Our Ref: 718742  
DPIE Ref: DA220-07-2002-I-Mod-12  
RFI Ref: RFI-35384212

**RESPONSE TO REQUEST FOR ADDITIONAL INFORMATION – MODIFICATION TO DEVELOPMENT CONSENT  
DA220-07-2002-I-Mod12, 1 DAMPIER STREET, BOWMAN NSW**

On behalf of the applicant, Teys Australia Southern Pty Ltd, please find below a formal response to the request for additional information provided by the Department on 01 February 2022. The below response adopts the points outlined within Attachment 1 of the request.

00A210 - 1
NOT FOR CONSTRUCTION

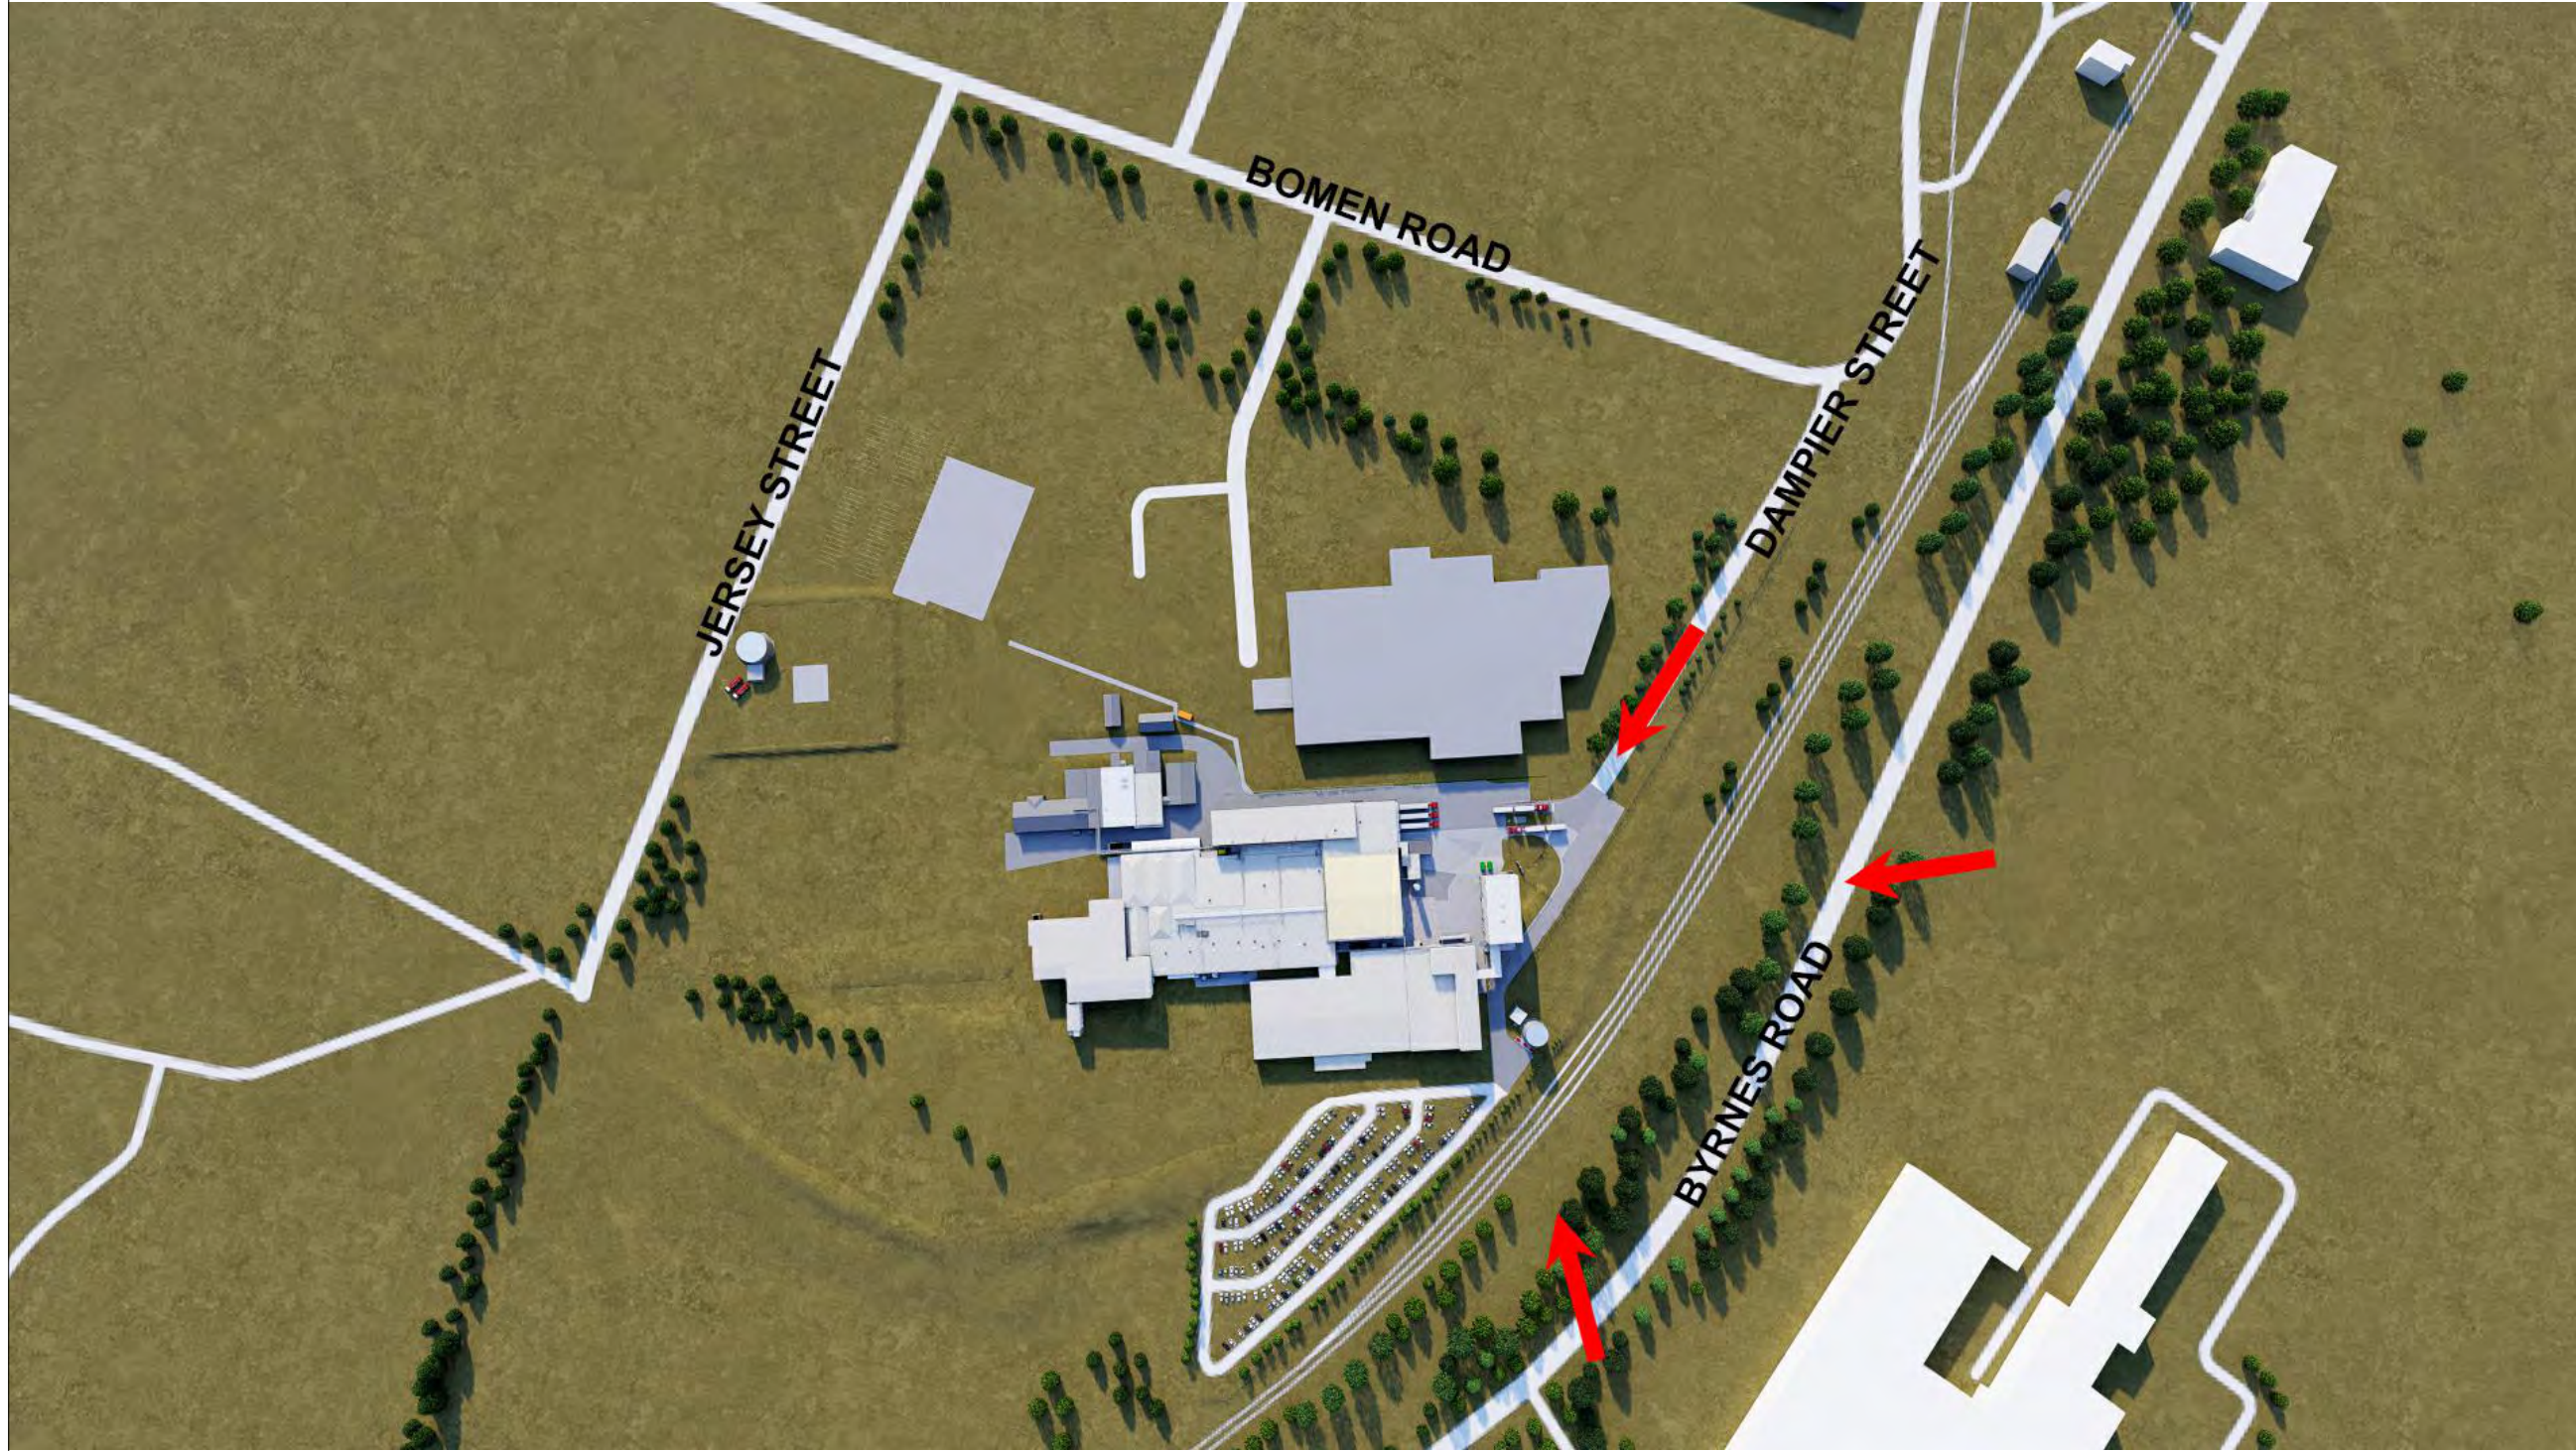
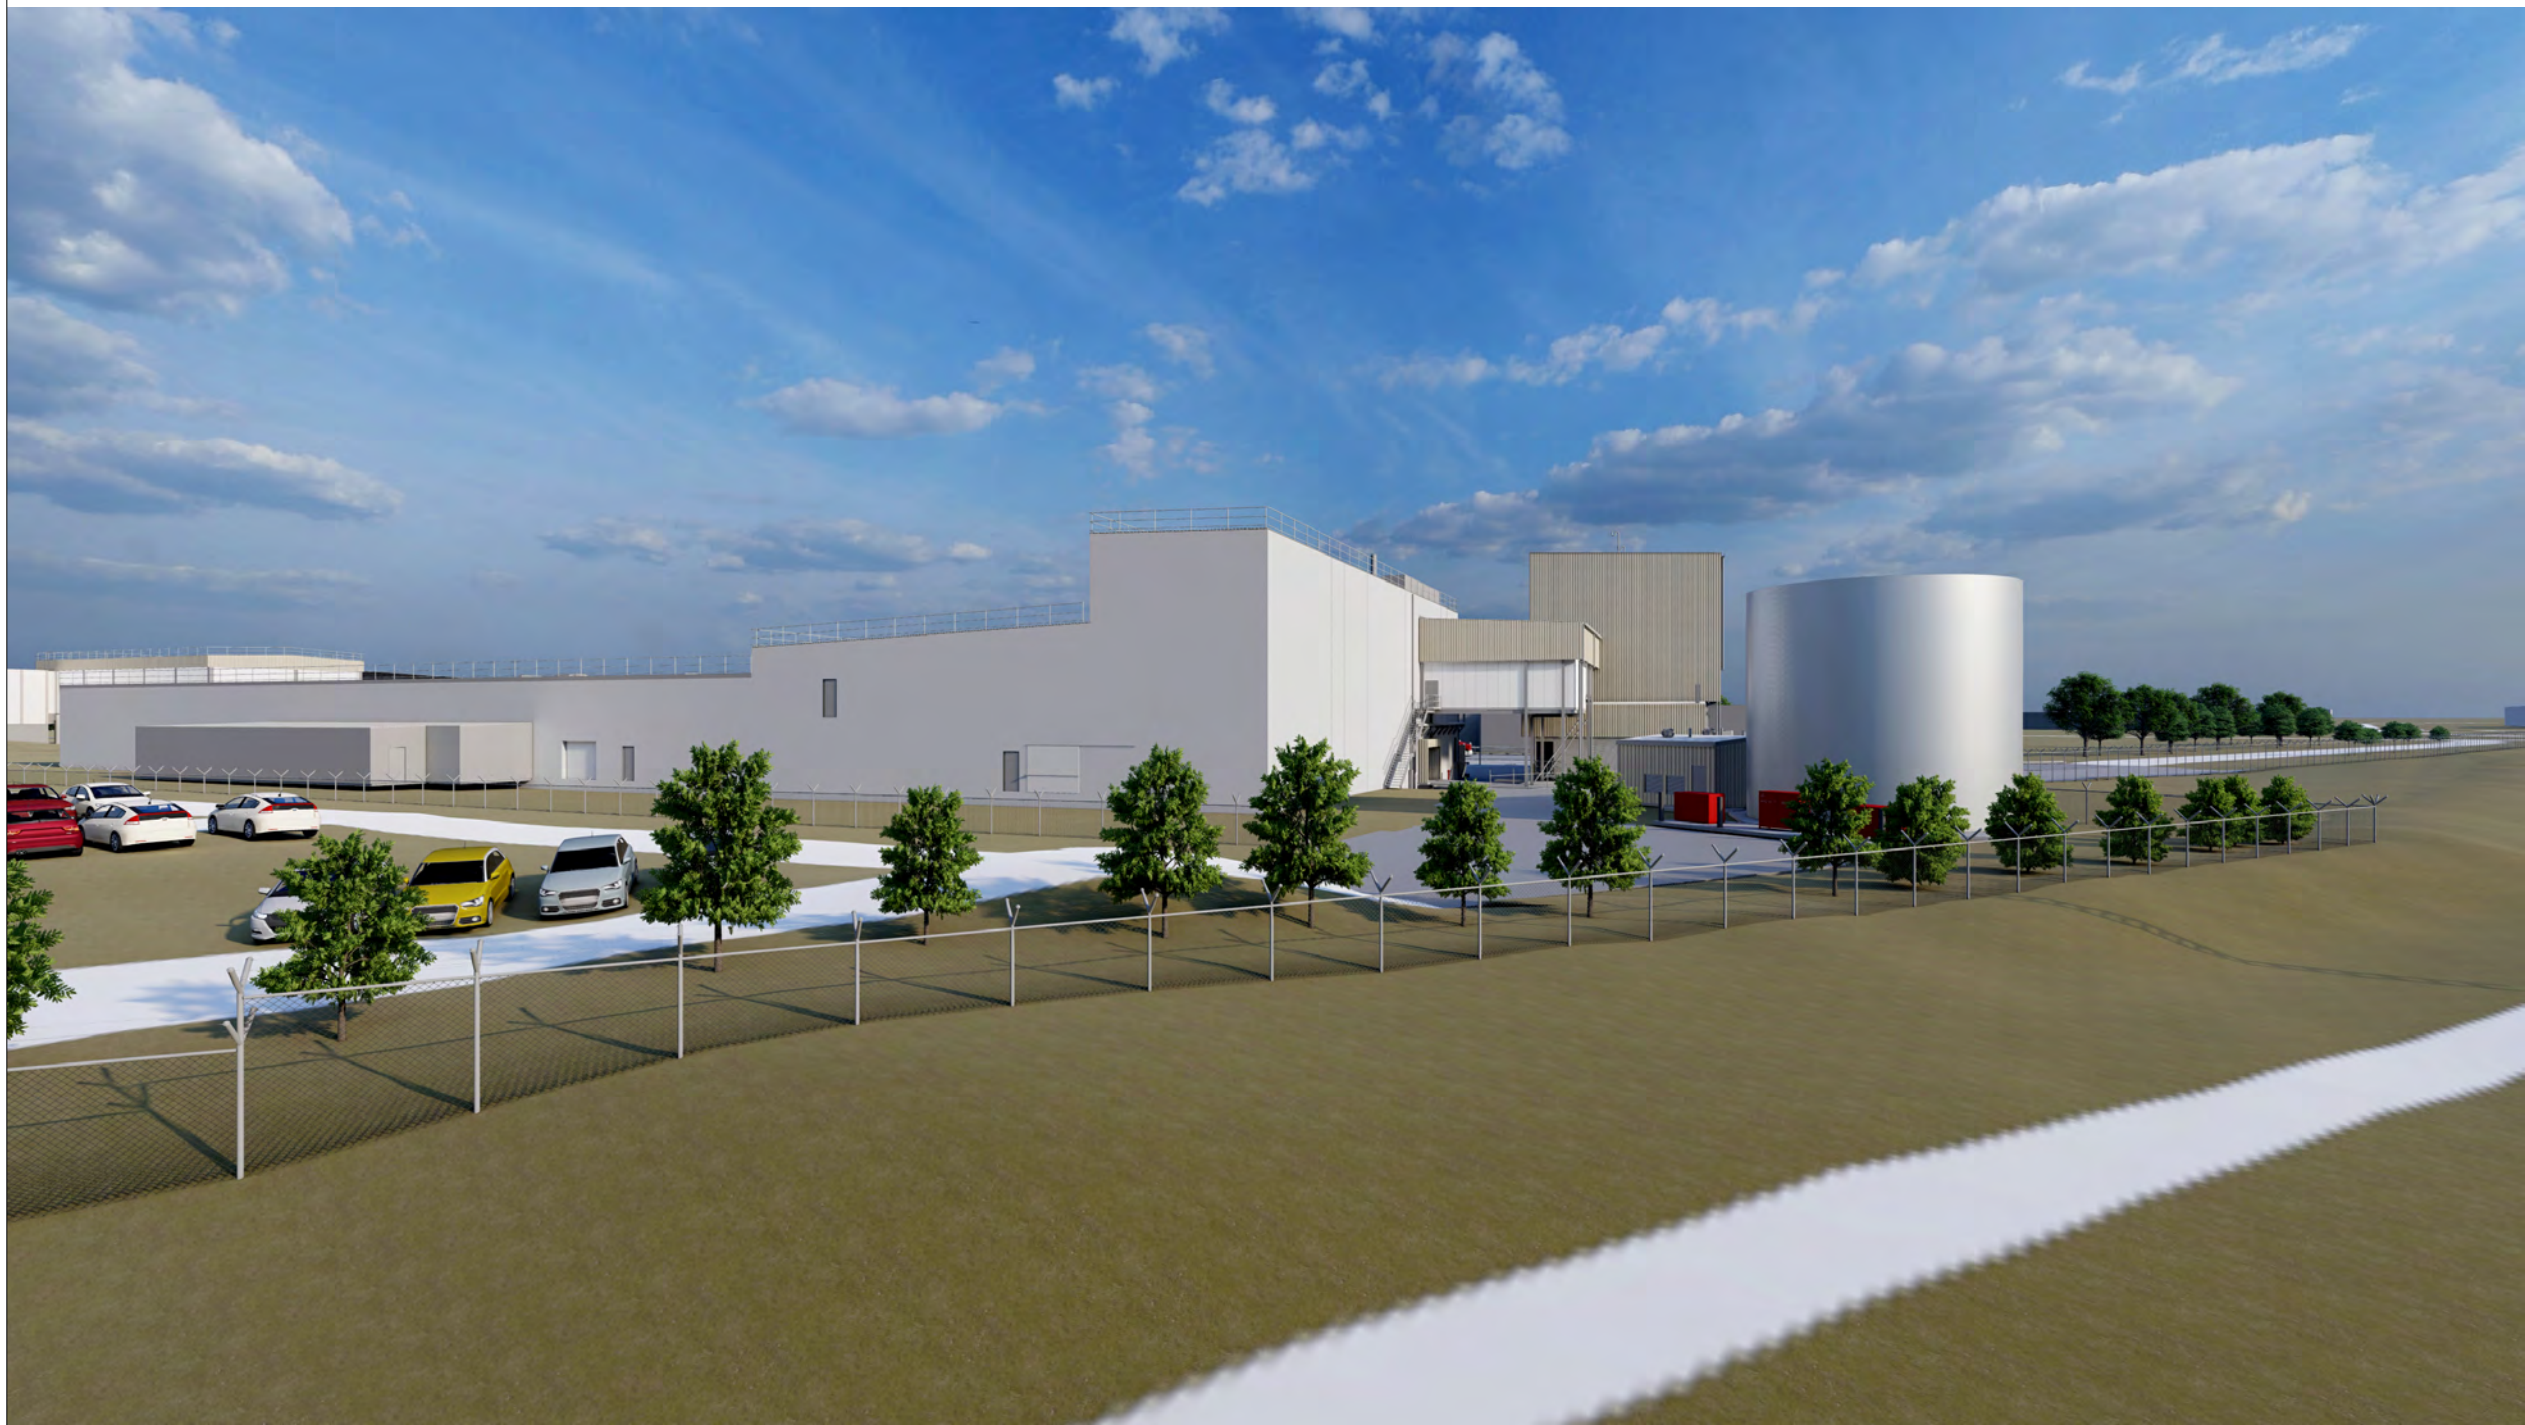
The proposed works include the construction of two buildings, with one building (Plate Freezer) over 18.5m in building height, yet the Report states “the proposed modification will be negligible in terms of potential visual impacts derived from any additional building height, bulk or scale”. Further details should be provided to confirm the visual relationship between the proposed works and the existing buildings and, if necessary, an assessment of potential visual impacts from public vantage points (e.g. Byrnes Road).

Elevation plans and 3D perspectives have been provided to support the assessment of the visual impact. The design, scale and bulk of the new Plate Freezer / Store complements the existing development and does not result in any adverse visual impacts.
